Mark E. Jones, PE
Structural Engineering and Design

Ref: Site Observations and Analysis
93 Warner Hill Ct.
Fuquay-Varina, NC 27526
Permit No. SFD2024-0080
Project No. 24-141

The plans for the above referenced site were reviewed on January 9, 2025 for the following items:

SECOND FLOOR PLAN

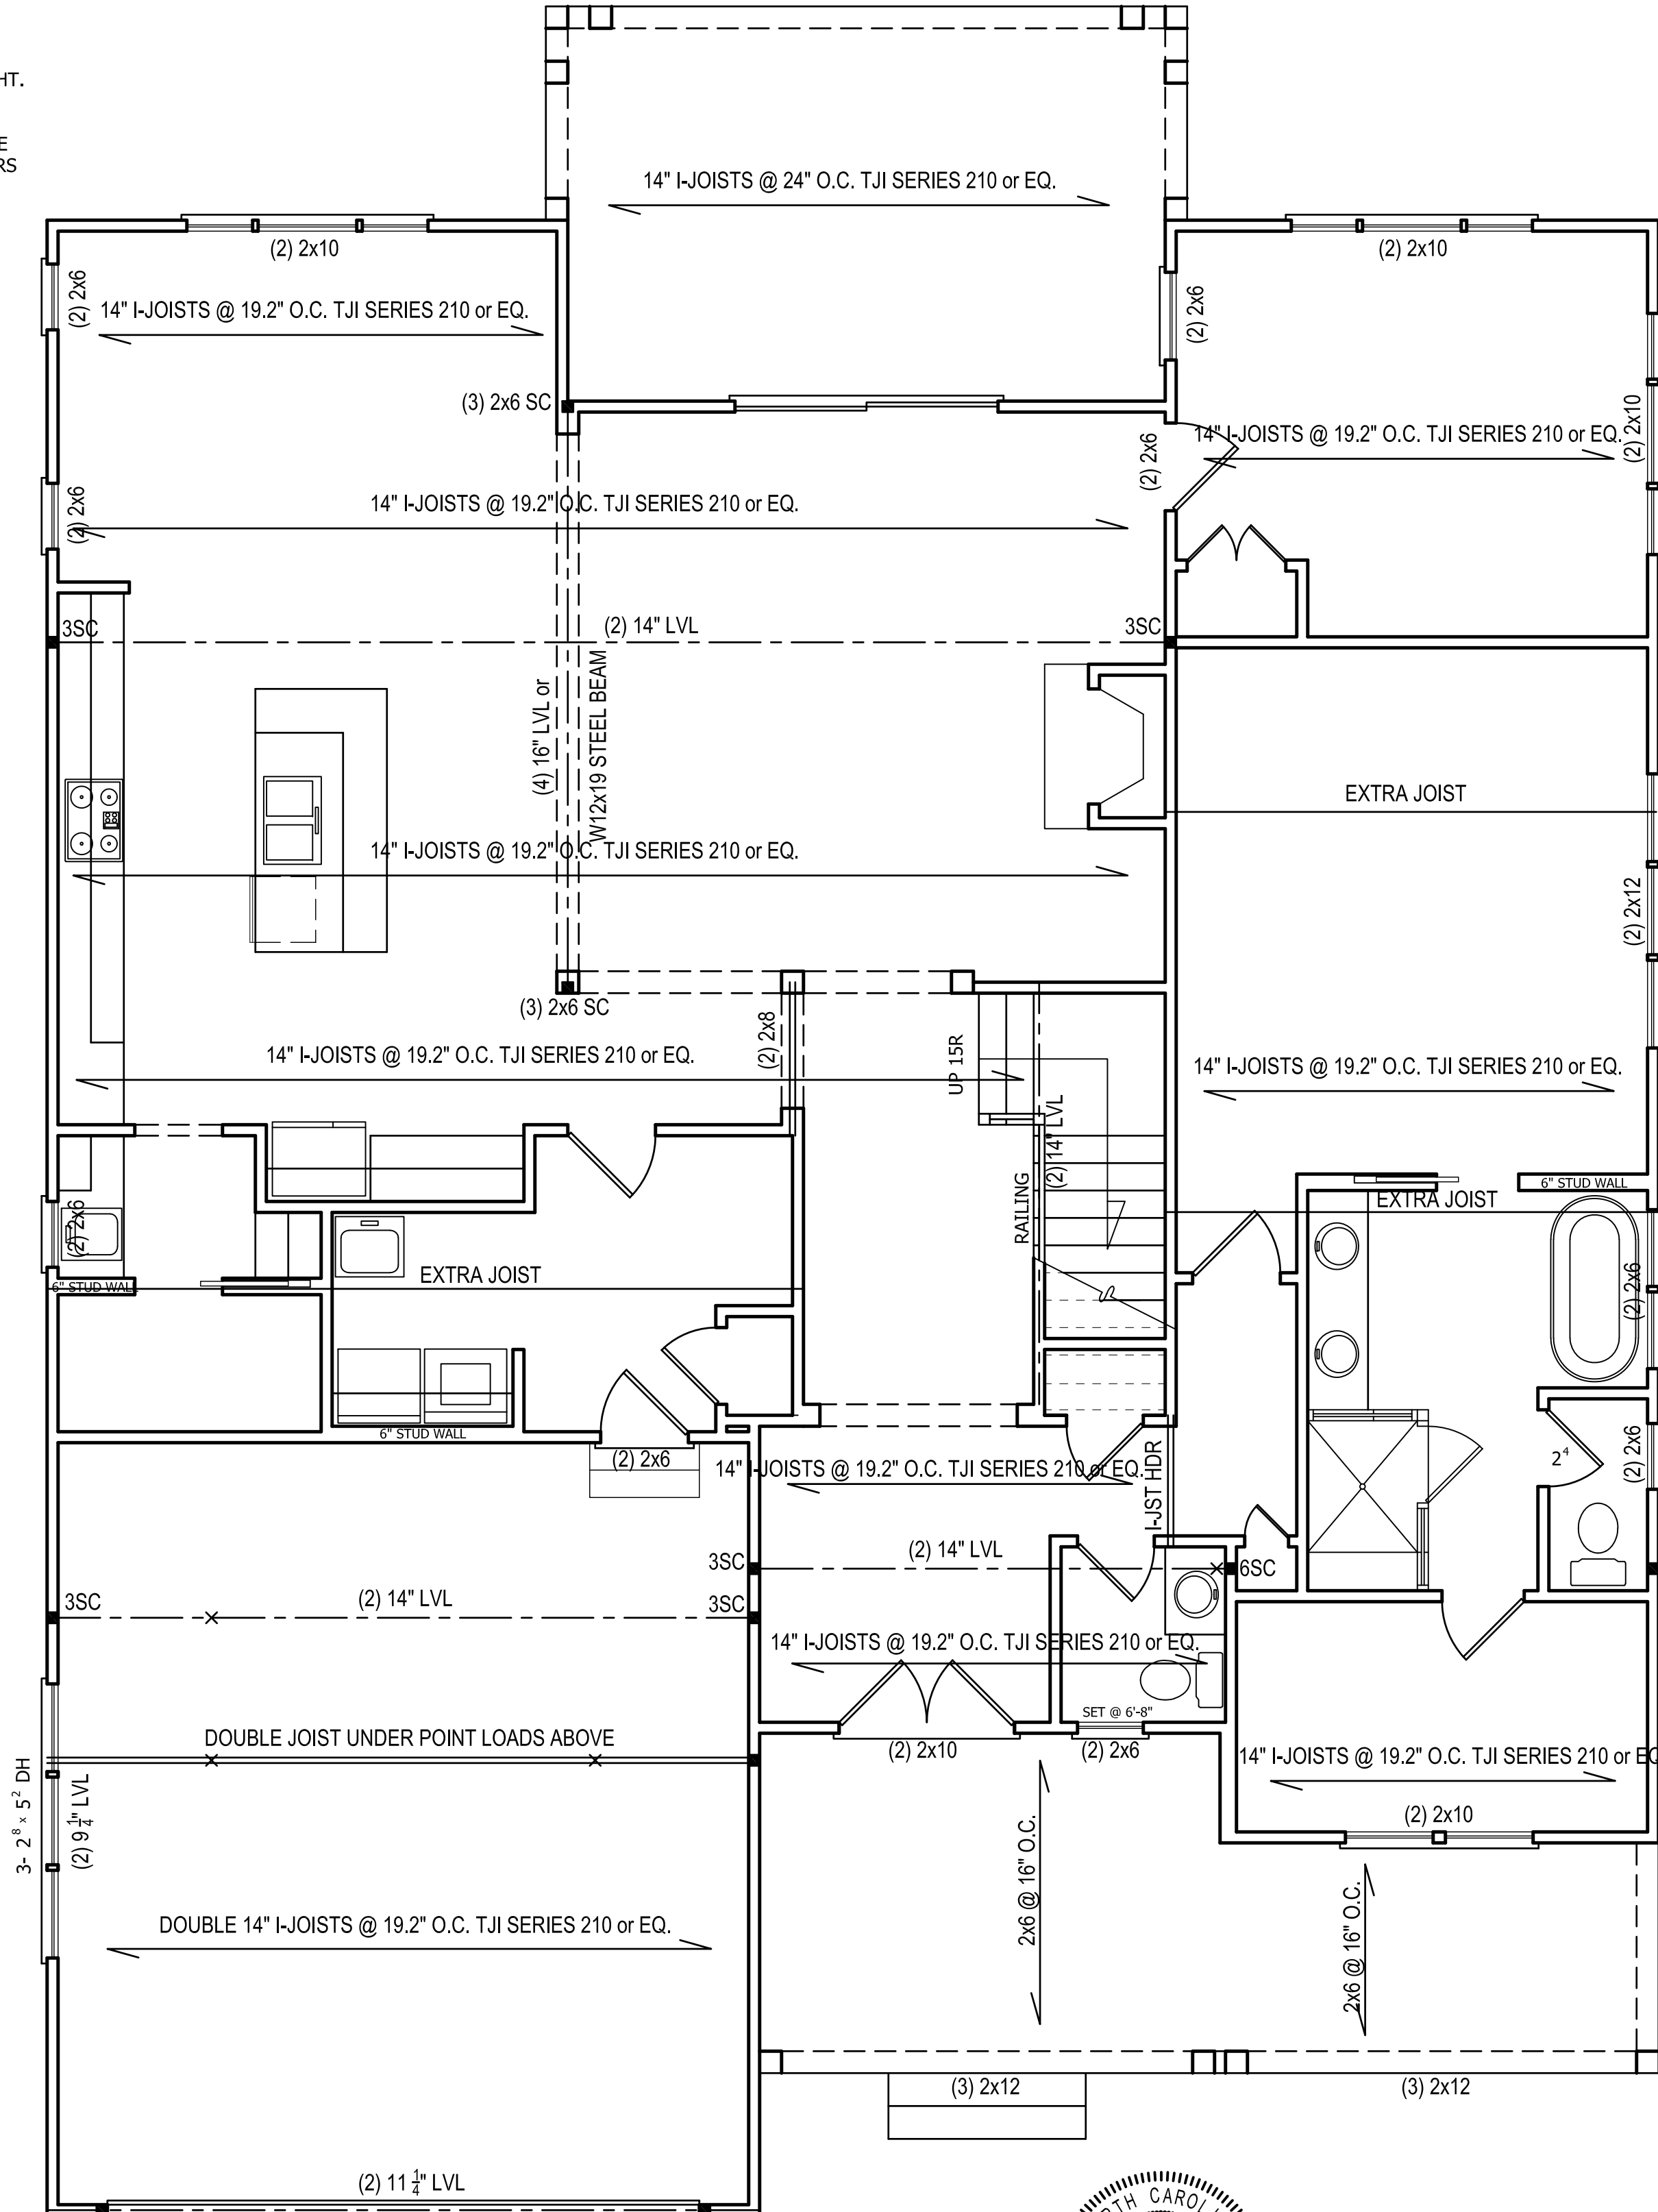
1. The builder has added a fourth bedroom on the second floor on the left side that was originally designated as attic storage. The second floor hall bath was also changed to a full bath. The rear wall of the bedroom 4 is load bearing and the wall lands between i-joists in the floor system below. Below the wall, the builder shall provide 2x6 blocking at 24" on center between the i-joists. The builder shall pack out the webs of the i-joists flush with the flanges and use joist hangers to support the new blocking.

The builder has added a full bath and moved the closet to the rear of bedroom 2. No structural revisions are required due to the alternate framing. The window in bedroom 2 has been furnished as a twin window in lieu of the two single windows as specified on the plans. The existing 2-2x6 header is adequate as installed.

The three windows indicated in the Loft have been installed as one triple window. The builder shall provide a 2-2x10 header above the unit in lieu of the plan specified 2-2x6 individual headers.
